Our Ref: R/2019/20/E
File No: 2021/561165
Your Ref: SSD-10384-Mod-1

Candice Pon
Planning Officer
Department of Planning, Industry and Environment

SSD 10384 MOD 1 – Removal and replacement of 2 trees on Gloucester Walk – Advice on Response to Submissions

The 2 sections below indicate the construction of the existing walls and footings at tree 50 and 51.

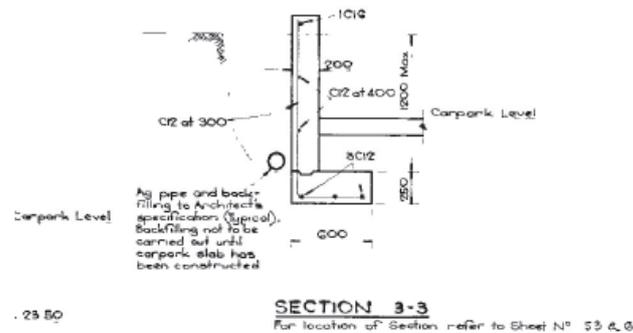
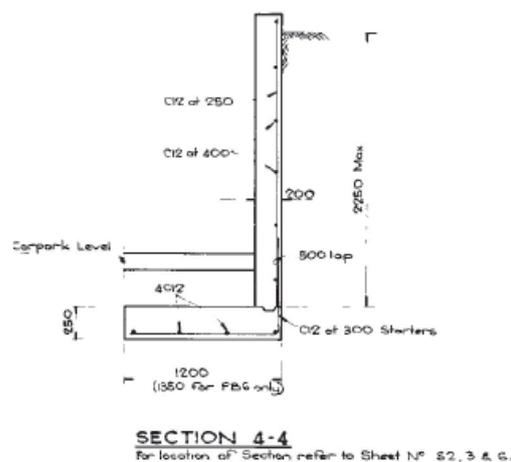
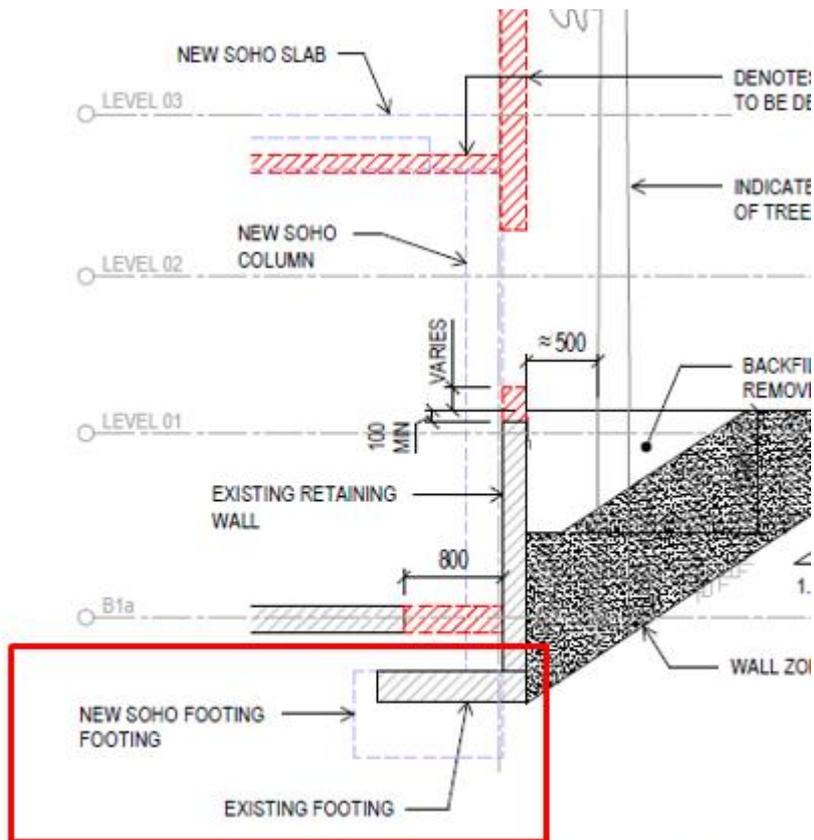
The structural engineer states that the wall has already failed, however, the trees are still standing, and no information of root plate instability has been reported. It is likely that tree roots are deflecting along the back of the wall (potentially stabilising the soil). Given the site constraints (west retaining wall) it is likely that the majority of the tree’s roots are growing east (away from the retaining wall). This means that the removal of the retaining wall (west) is less likely to cause whole tree failure towards the east. The trees are restrained from failing west due to the proximity of the existing building.

Only one method of installing a new wall in front of the existing wall (within the basement) has been explored. This method would require large machinery that does not fit in the available space and demolition of existing footing. Other excavation methods and designs to construct a new wall in front of the existing wall and footing have not been explored. Note: The structural engineer reports refer to wall failure but not failure of the existing footing.

- 1) Constructing the new wall and footing in front of the existing wall and footing without the use of large machinery. The existing retaining wall would be maintained with a new retaining wall and footing located within the carpark. See Option B annotated on the image below (NB: drawing requires separate review by a qualified structural engineer).

Refer to Appendix A for detailed sketches.

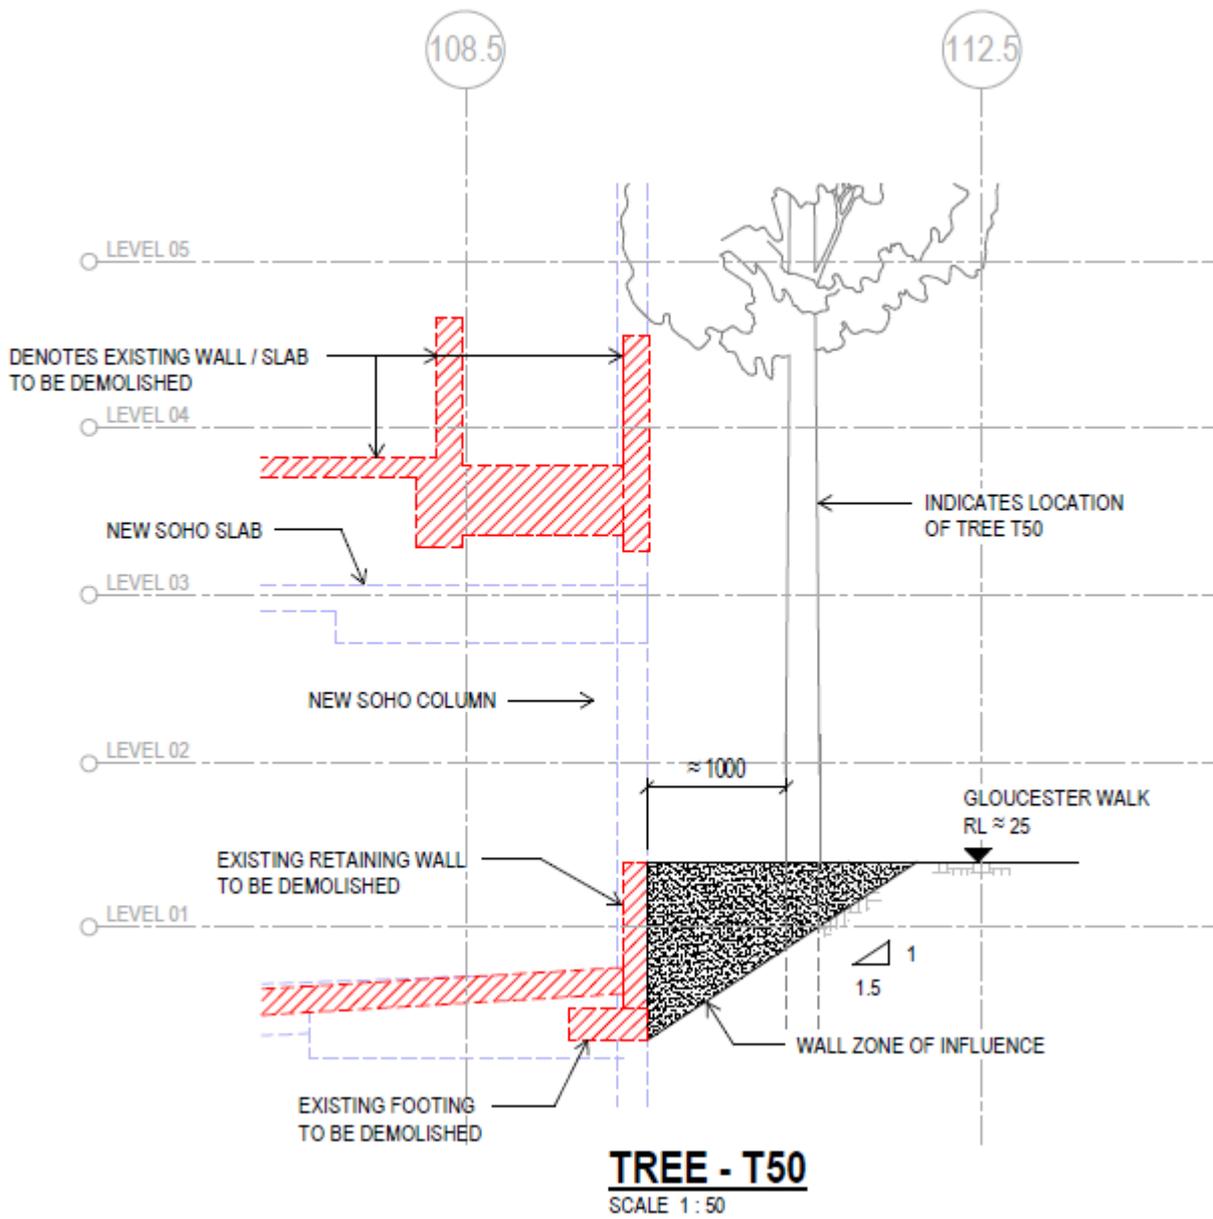
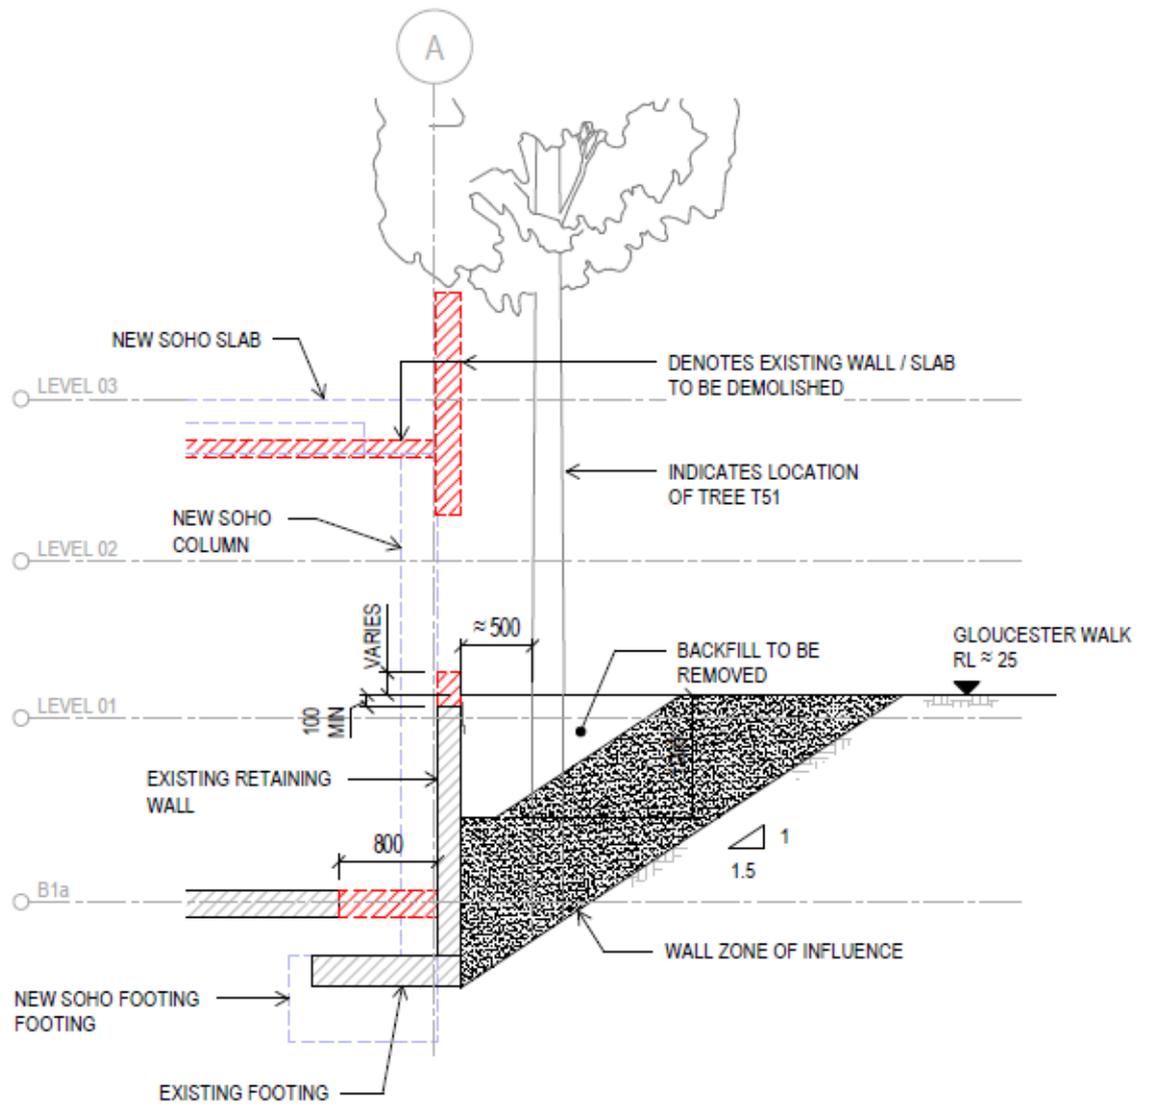
SCP has proposed two alternative options that would retain both trees i.e. rock anchors and a new wall in front of existing wall:

The letter prepared by SCP dated 9 December 2021 states that the minimum rock anchor length required is 6 metres and that the maximum length available is 6

metres. This could be a viable option if further explored and accurate measurements were considered.
